Attachment to Drainage Report J10-D10

RE: REVISED GRADING & DRAINAGE PLAN FOR WAREHOUSE COMPLEX AT
1301 64 th ST. NW (J10-D10) RECEIVED AUGUST 24, 1984

REF: DRAINAGE REPORT FOR WAREHOUSE COMPLEX AT 1301 64th
STREET NW (J10-D10)

REF: DRAINAGE REPORT FOR WAREHOUSE COMPLEX AT 1301 64TH STREET NW
(J10-D10) RECEIVED MARCH 22, 1984

GRADING AND DRAINAGE
PLAN OF
SOUTHERLY PORTION OF TRACT 266
AIRPORT UNIT
TOWN OF ATRISCO GRANT
BERNALILLO COUNTY, NEW MEXICO

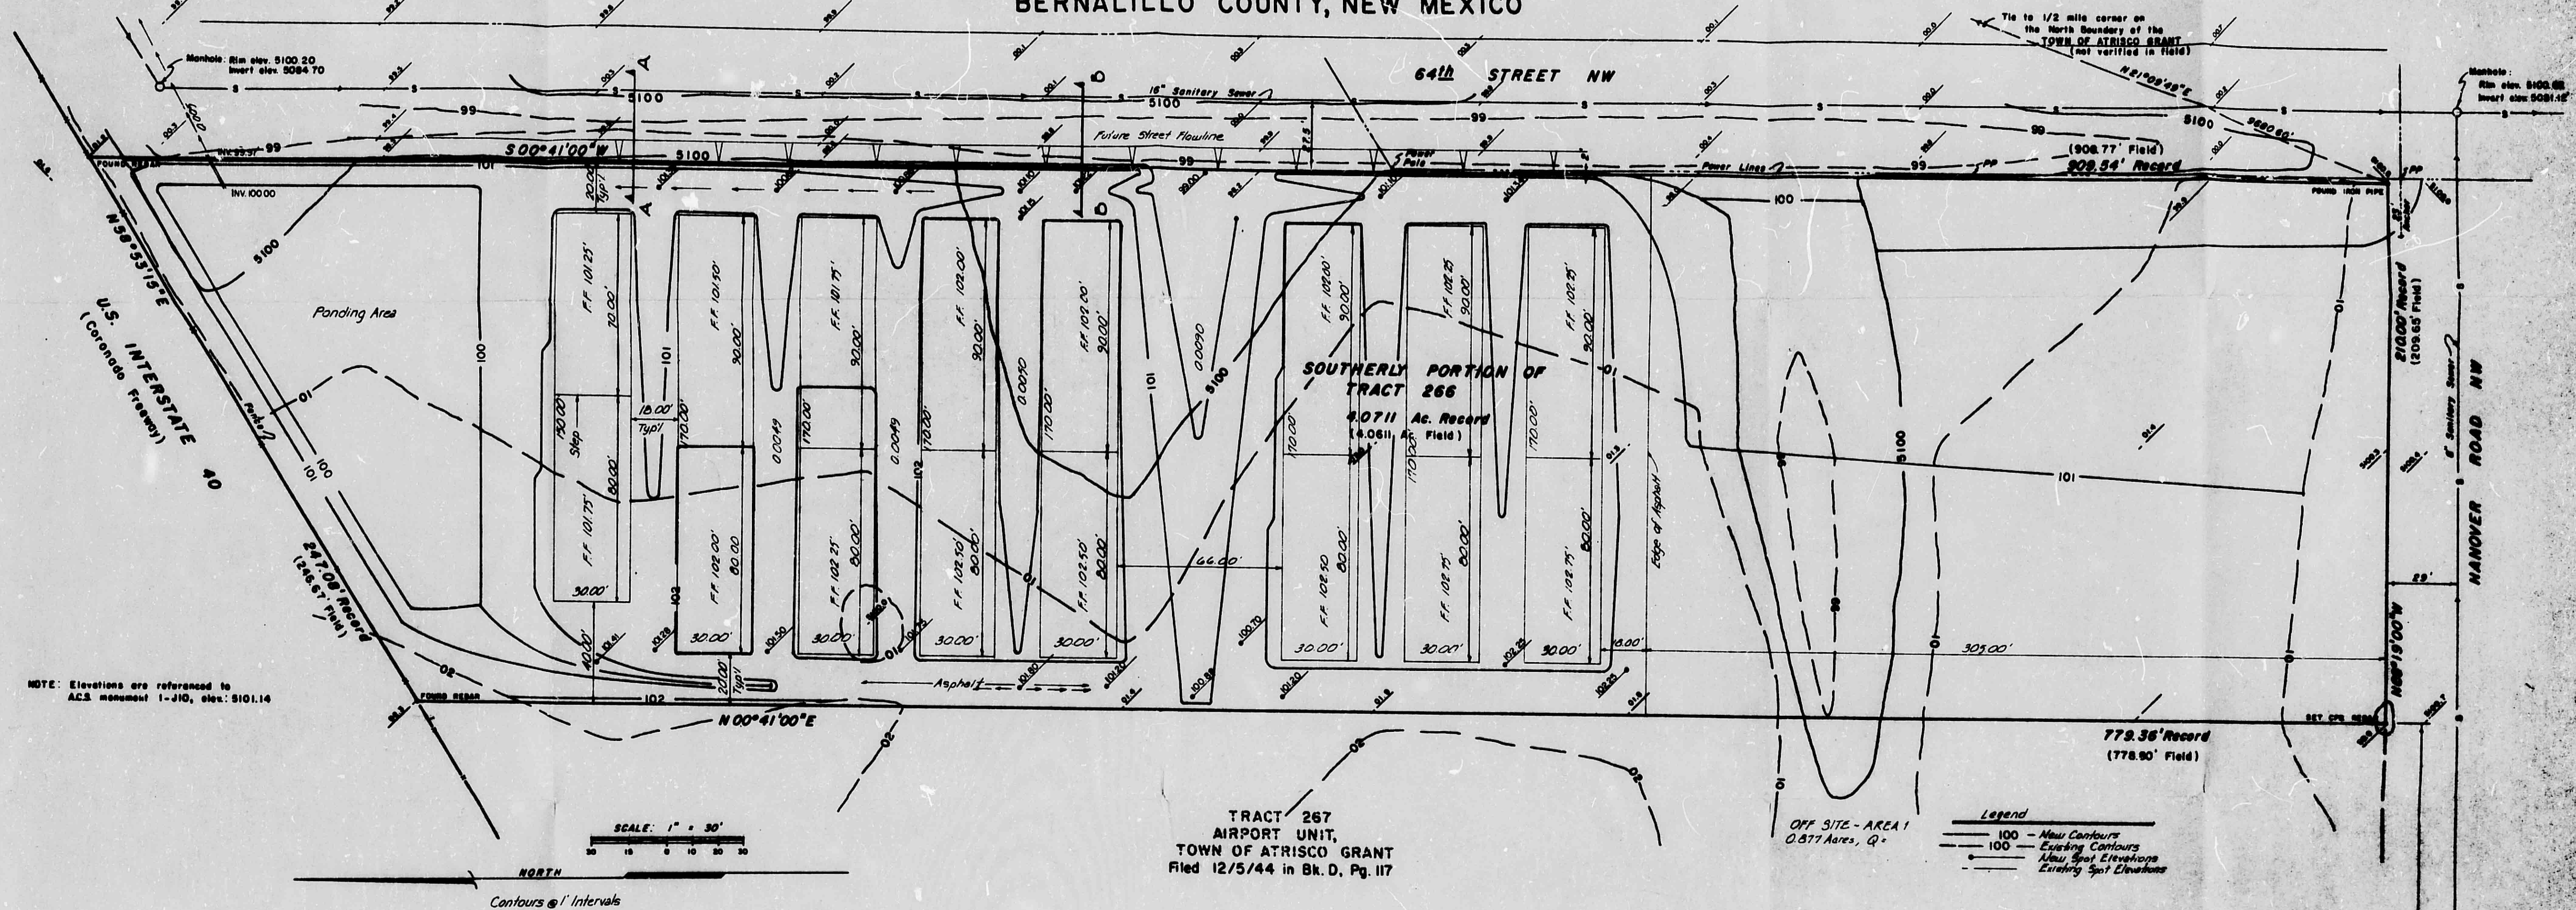
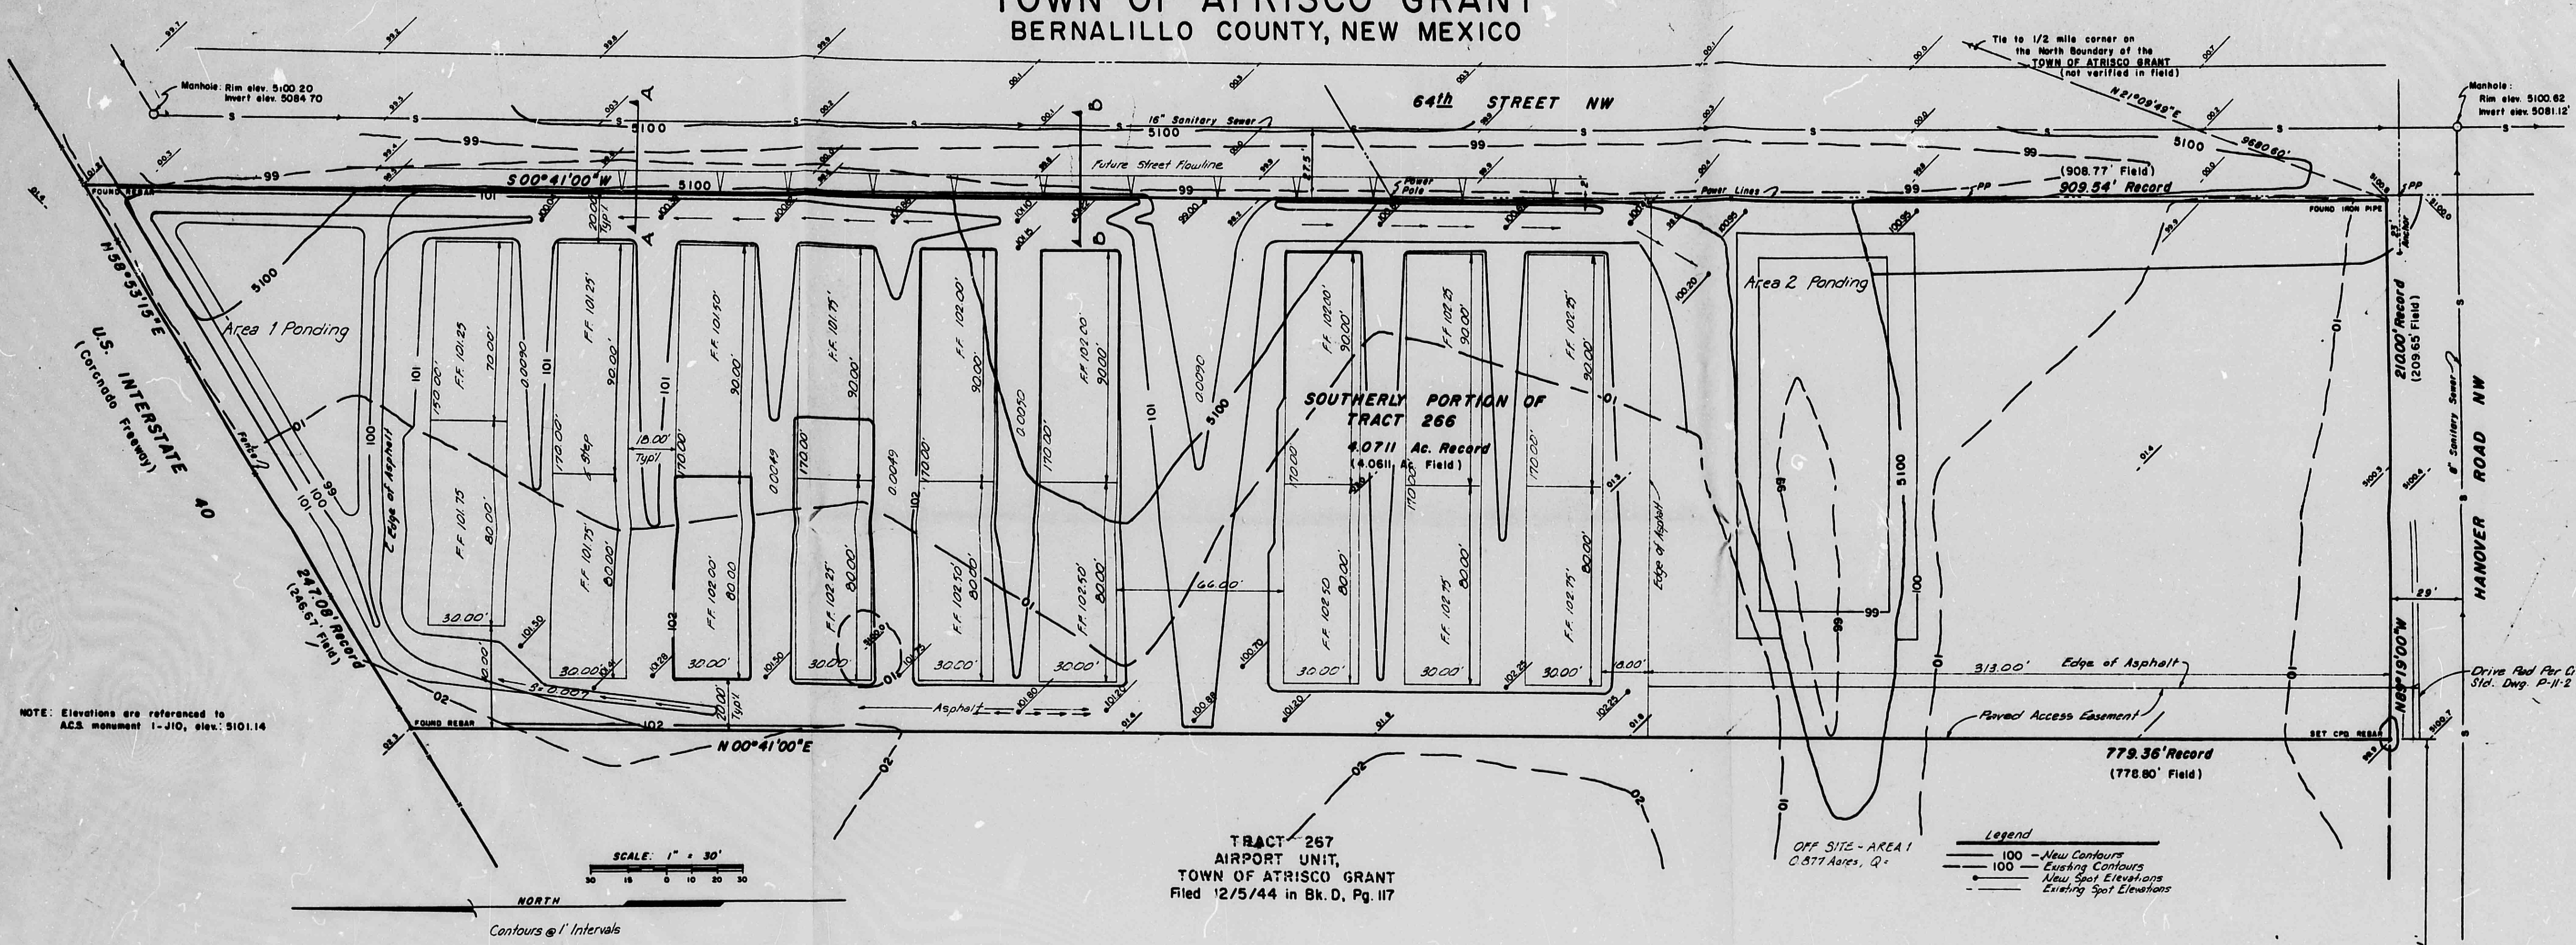
- Zoning*
5-YEAR UNDEVELOPED
1. As per the pre-design, a paved access is required. Whether the paved access is constructed through a paving district or by other means, the construction will need to be assured prior to release of the building permit.
 2. It is mentioned in the report that 5.10 cfs will be the discharge rate from the pond. How was this rate determined to be the allowable.
 3. There is no mention of where the flows go or what the impacts will be once they leave the site.

1. As per the pre-design, a paved access is required. Whether the paved access is constructed through a paving district or by other means, the construction will need to be assured prior to release of the building permit.
2. It is mentioned in the report that 5.10 cfs will be the discharge rate from the pond. How was this rate determined to be the allowable.
3. There is no mention of where the flows go or what the impacts will be once they leave the site.

In response to your letter of April 11, 1984, the following listed items correspond to items 1 through 3:

1. No Department has required any approved grades or paving since 64th Street is being put in a paving district. No erosion will take place as a result of this construction other than can now take place undeveloped. It would not seem feasible to require 1/2 of 64th to be paved at the owner's expense then make him pay again when assessment is required.

2. The value of 5.1 cfs was incorrect. The allowable pond discharge has been recalculated based on Q_5 undeveloped.
3. The flows leaving the site will enter 64th, then:

- a) flow from Ponding Area 1 will go to Iliff. No impact is expected since the flow is less than Q_5 undeveloped.
 - b) flow from Ponding Area 2 will go to Hanover Road. No impact is expected for the same reason as (a) above.

- c) Flow from off-site will be the most significant. The flow will probably continue across 64th and be dissipated against the existing wall. The flow will then be directed to Iliff and Hanover.
